Howerton Services, PLLC
License # P-1716
3513 Cathedral Bell Road
Raleigh, NC 27614
(919) 270-3460

Subject: 251 Keith Weathers Road
Fuquay Varina, NC 27526
Summers Plan Revision Letter
Harnett County Permit #: SFD2407-0104

Based on the request of the Contractor, 1 item was modified in the approved plans. My assessment and recommendations are as follows:

FIRST FLOOR PLAN

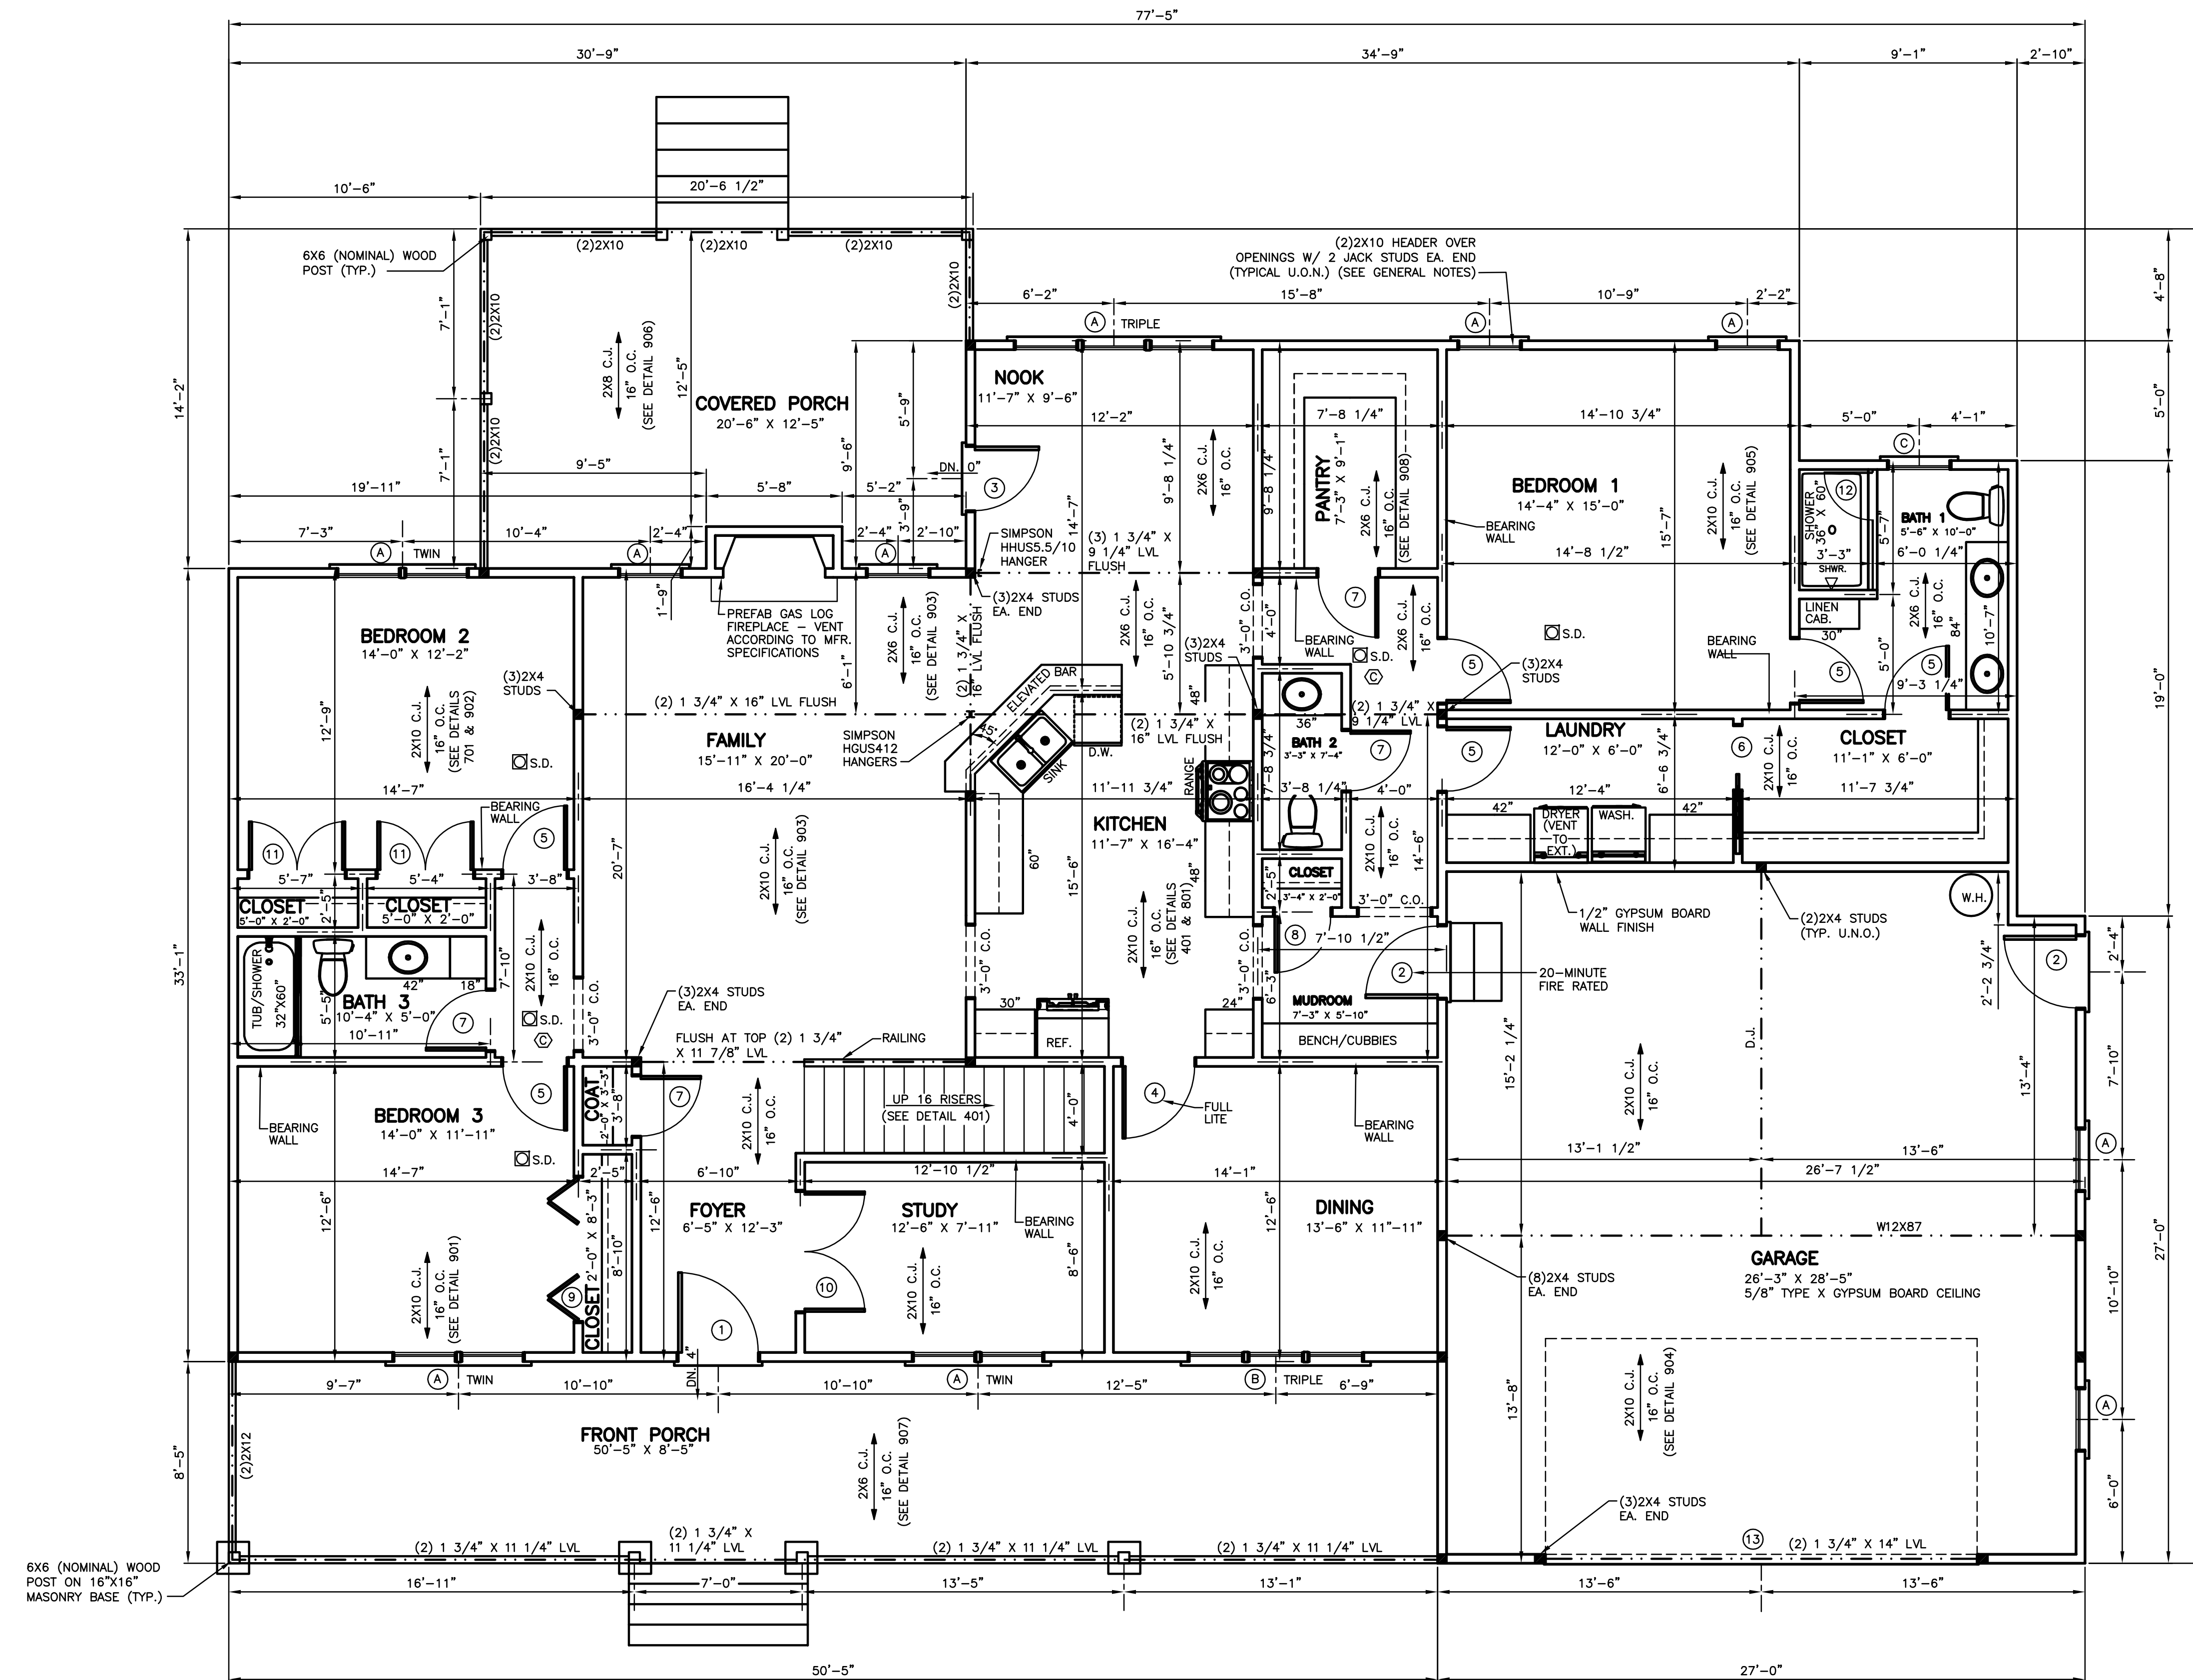
- Item 1: The beam for the floor over the Garage is a W12x87 steel beam. The Contractor requested changing the steel beam to an LVL beam. The LVL beam will be a triple 1 3/4"x 24" LVL with 5 studs under each end. Fasten the LVL members together with 2 rows of 1/4" x 5" structural screws spaced at 12" o.c. The new LVL beam is acceptable.
